KITTITAS COUNTY COMMUNITY DEVELOPMENT SERVICES

RE: Anderson Boundary Line Adjustment (BL-15-00016),

Map Number 16-23-18020-0002 Parcel Number 584833

Map Number 16-23-18020-0003 Parcel Number 654833

GOV'T LOT 1, SECTION 18,  
TOWNSHIP 16 NORTH, RANGE 23 EAST, W.M.

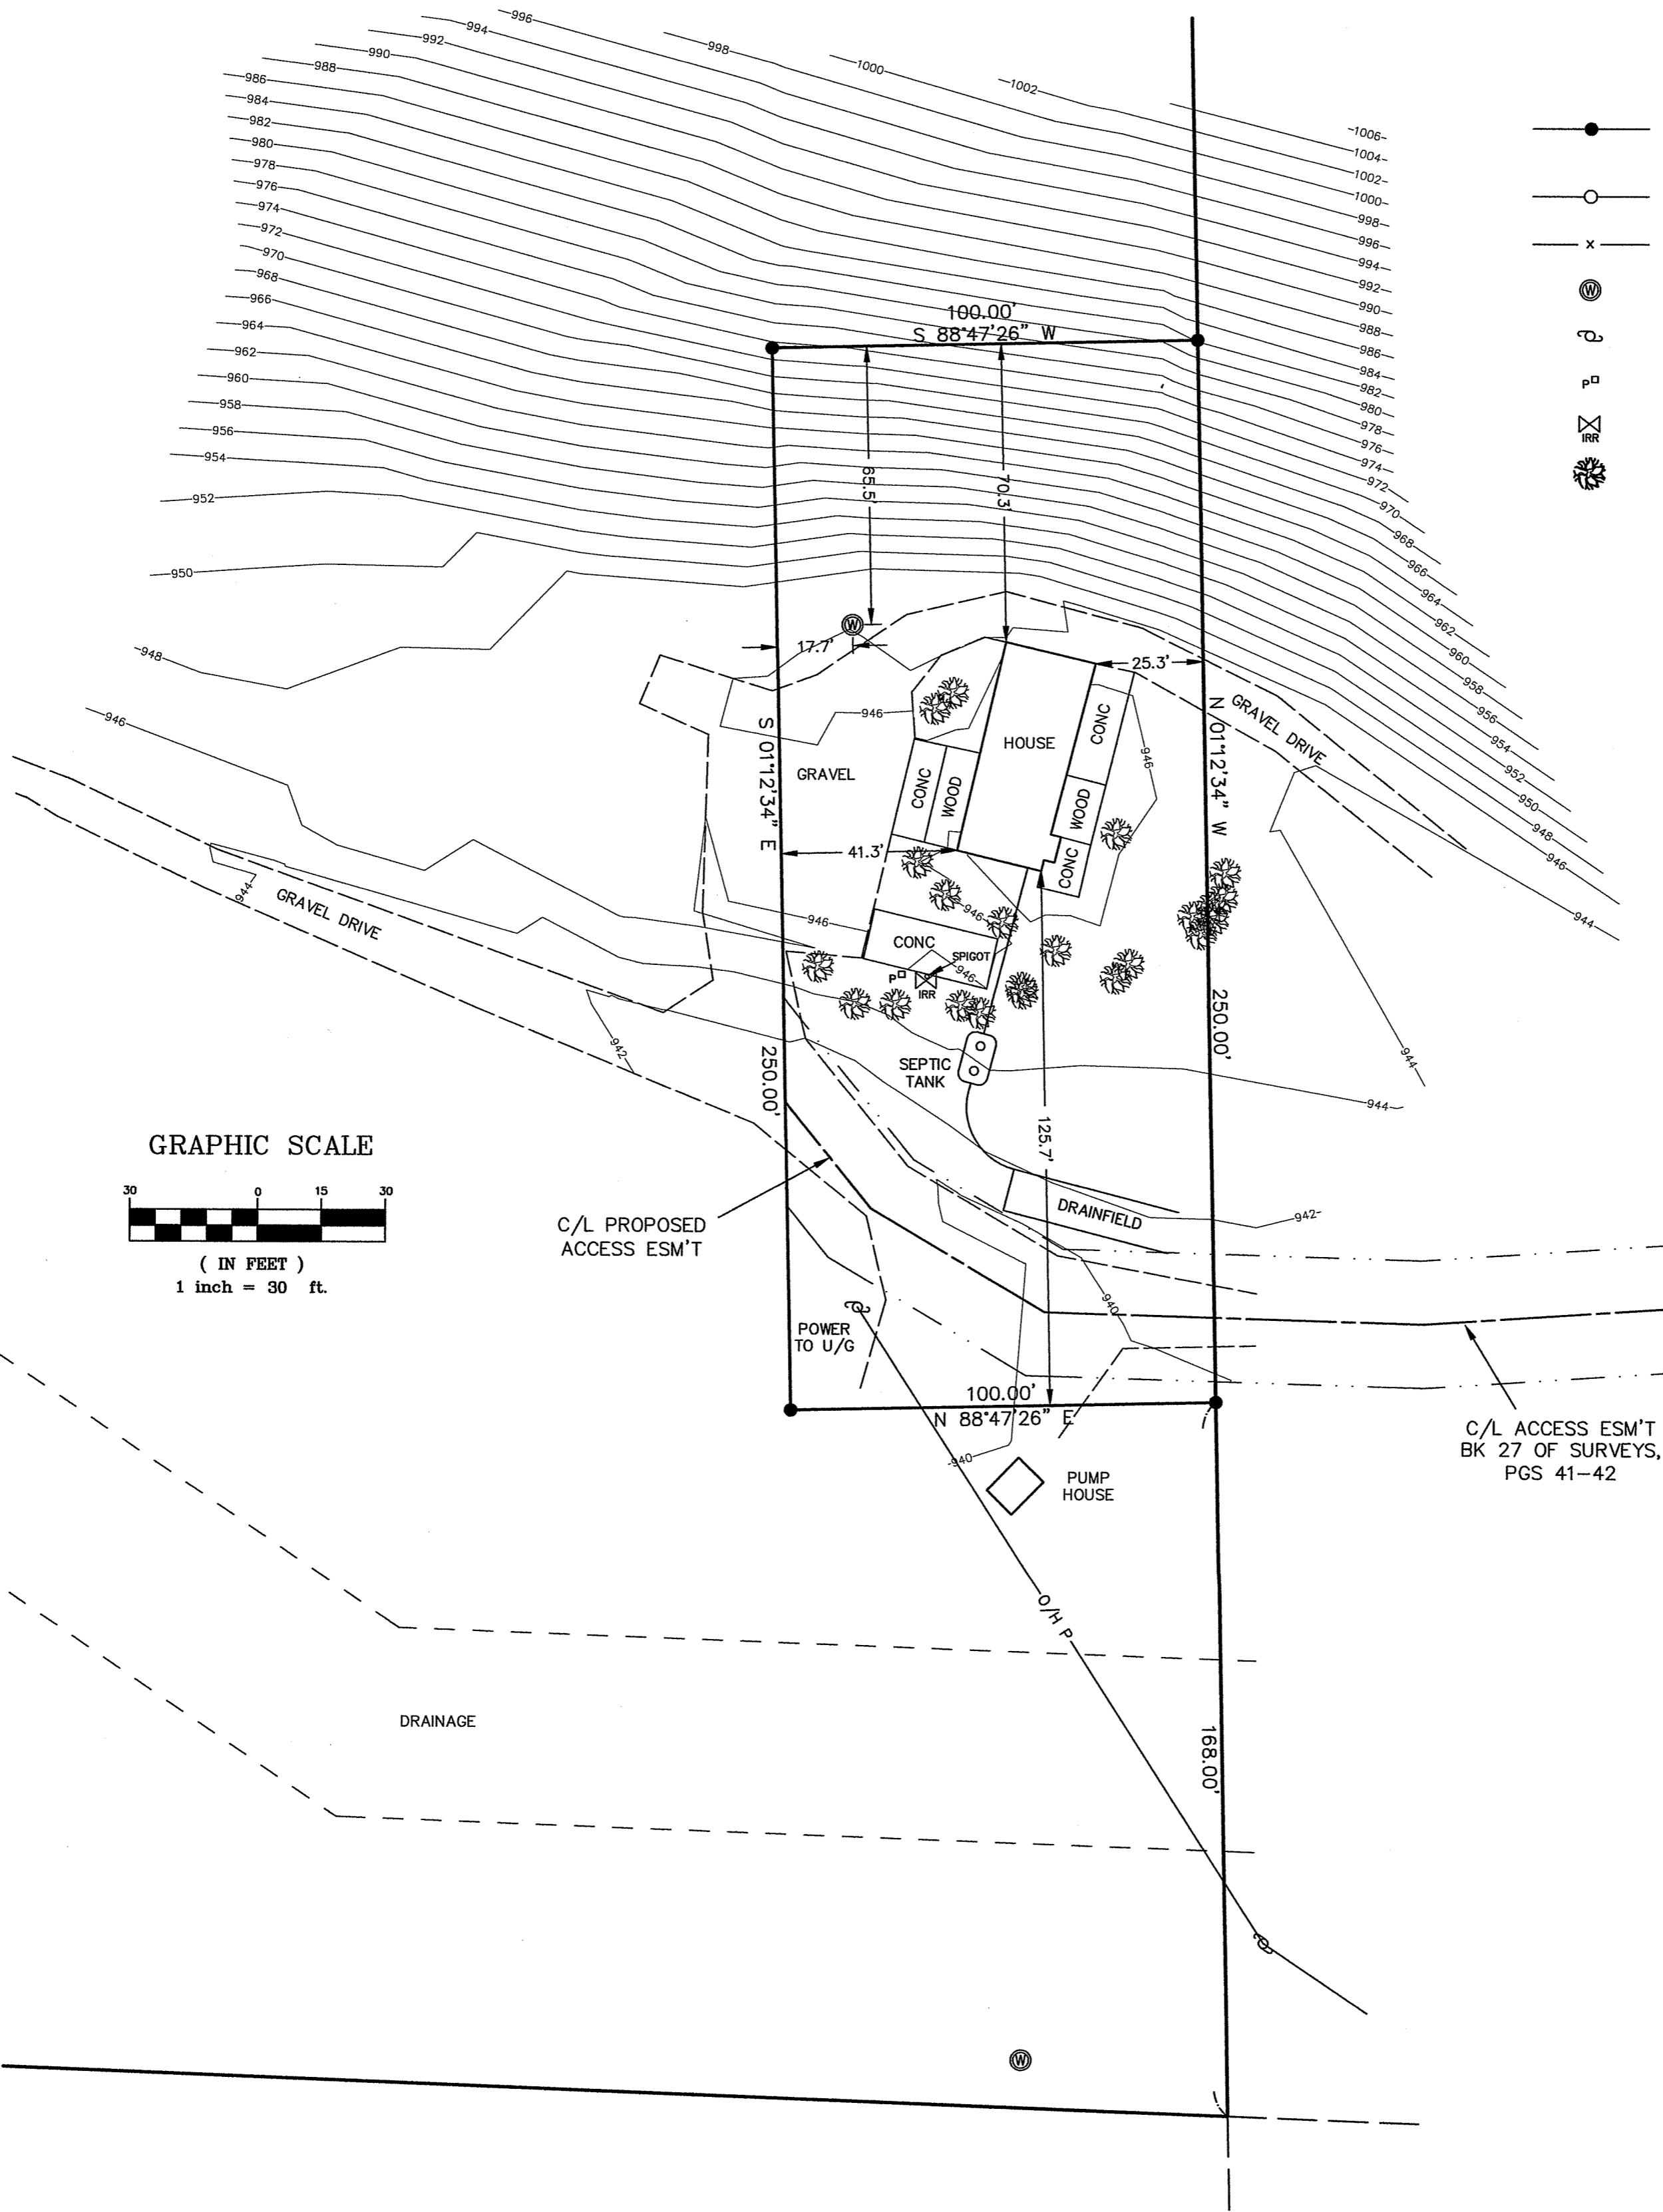
1. A recorded survey displaying legal descriptions and the new acreage and lot dimensions of each parcel must be submitted to our office prior to final approval.
2. An easement extension must be created and recorded to provide access to both parcels.
3. The existing septic system must be at least ten feet away from any newly proposed property lines.
4. A recorded shared well user's agreement for the well that is intended to serve both parcels.
5. Full year's taxes need to be paid for all tax parcel numbers per requirement of the Kittitas County Treasurer's Office.
6. Please refer to the attached Kittitas County Public Works and Kittitas County Fire Marshall comment memos for information regarding additional requirements.
